Application No: BE/149/20/PL
Site Address: 339 Chichester Road Bersted PO21 5AN
Description of works: Replacement of blockwork boundary wall with fence & new vehicular access. This site is in CIL Zone 4 (Zero Rated) as other development.

Thank you for your internet representation made on 12th January 2021 which has been recorded as an objection with the comments as follows:

SITE PLAN

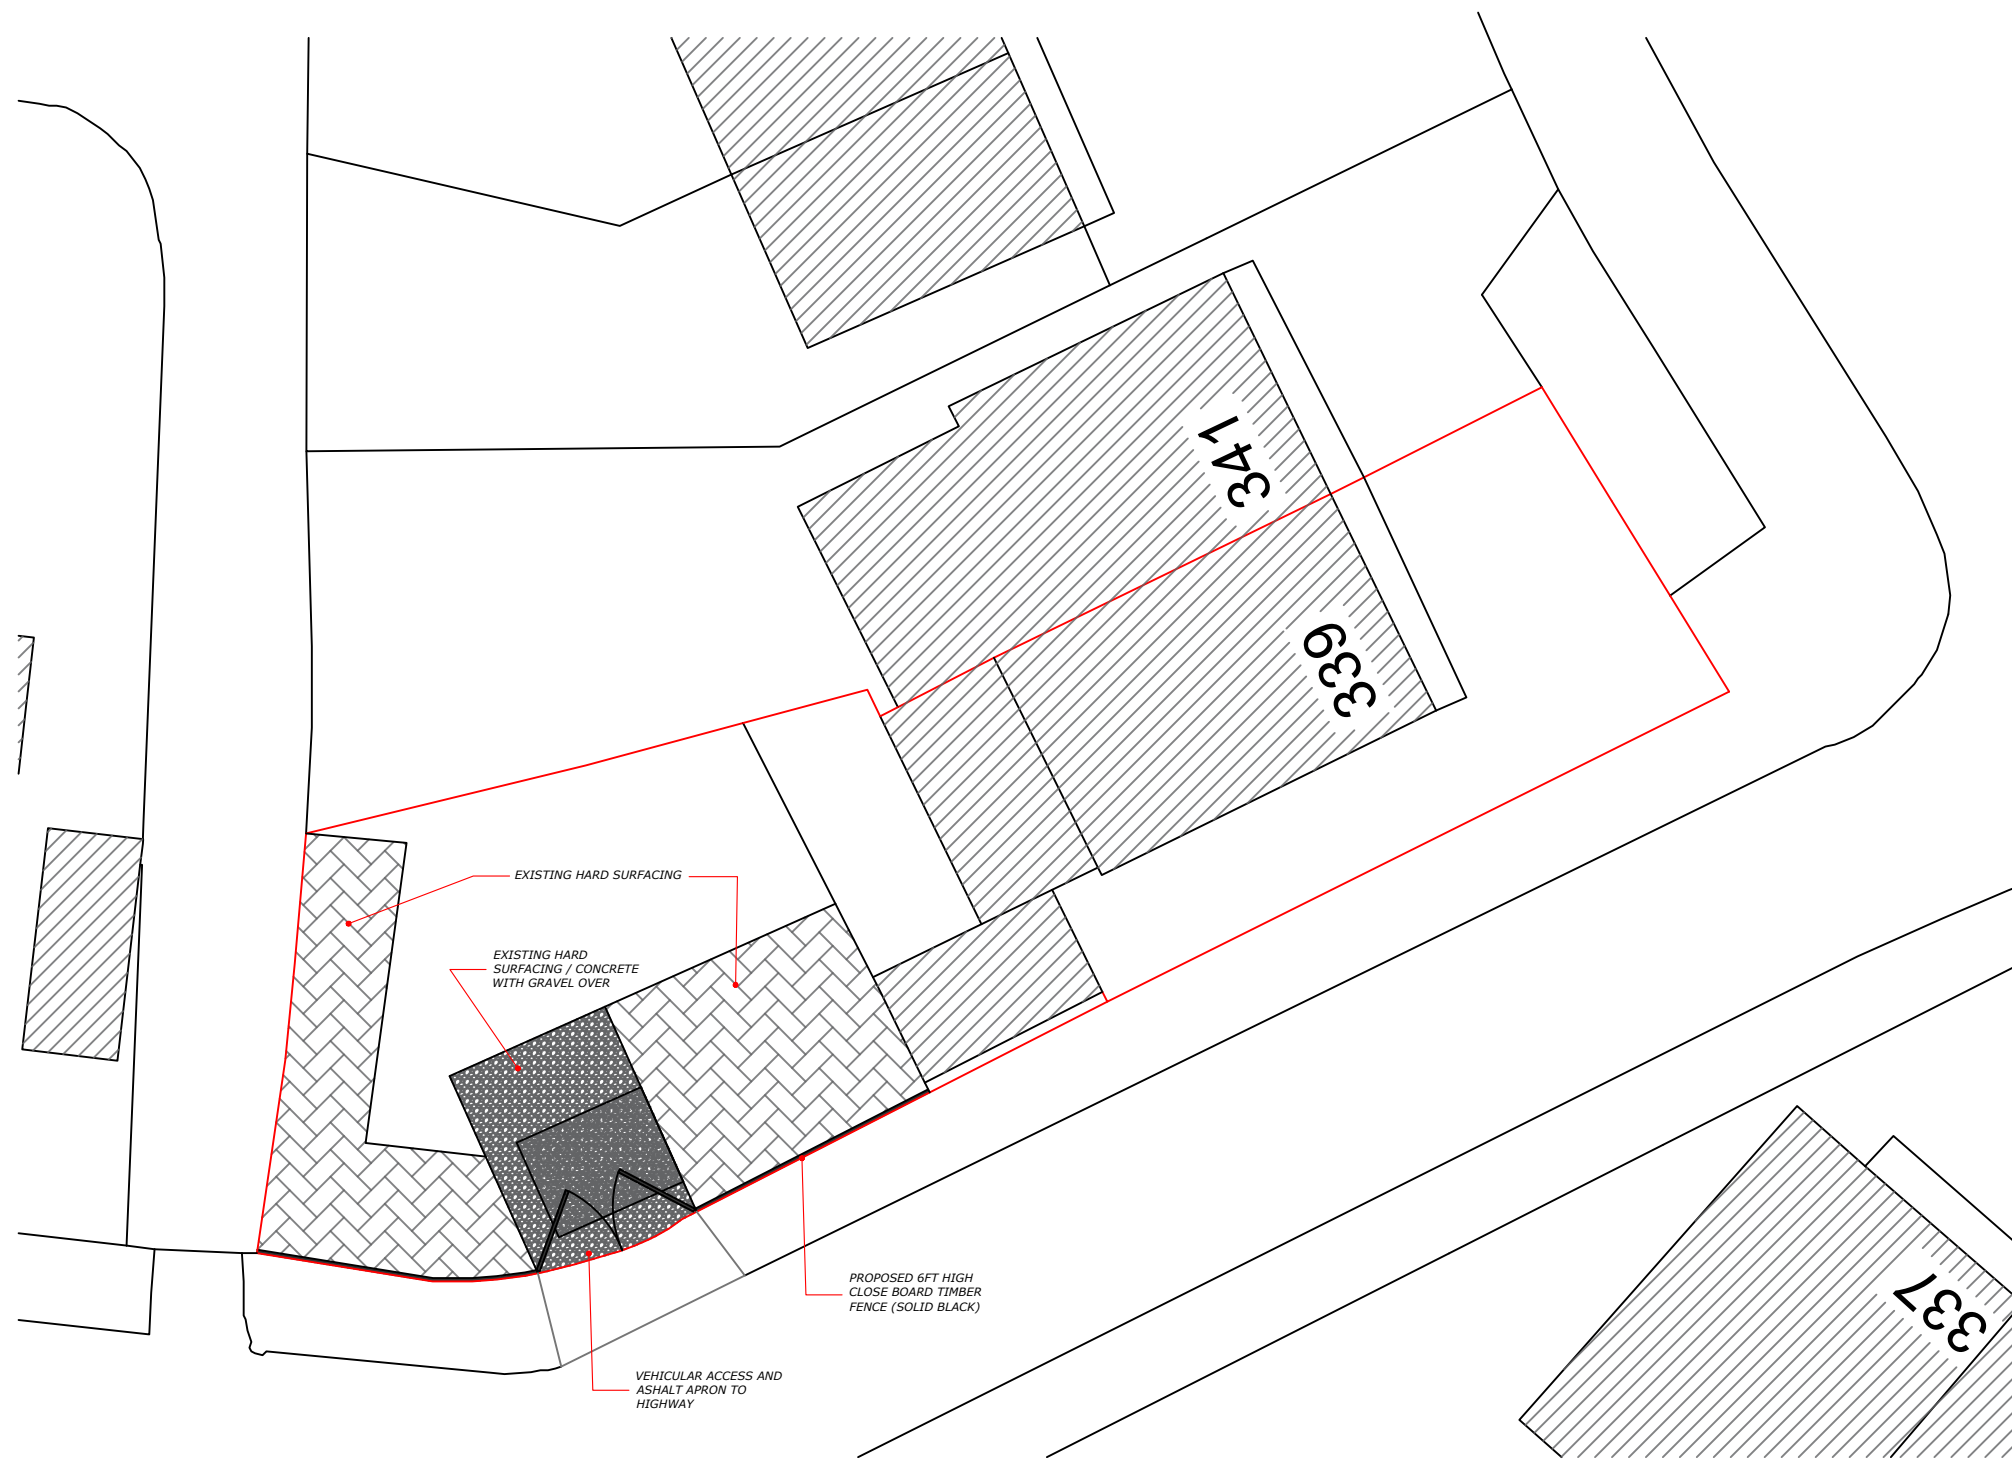
I believe this to be a hazardous sighting for vehicular access due to lack of visibility so close to a bend and a junction opposite. This property already has a large paved parking area at the front.
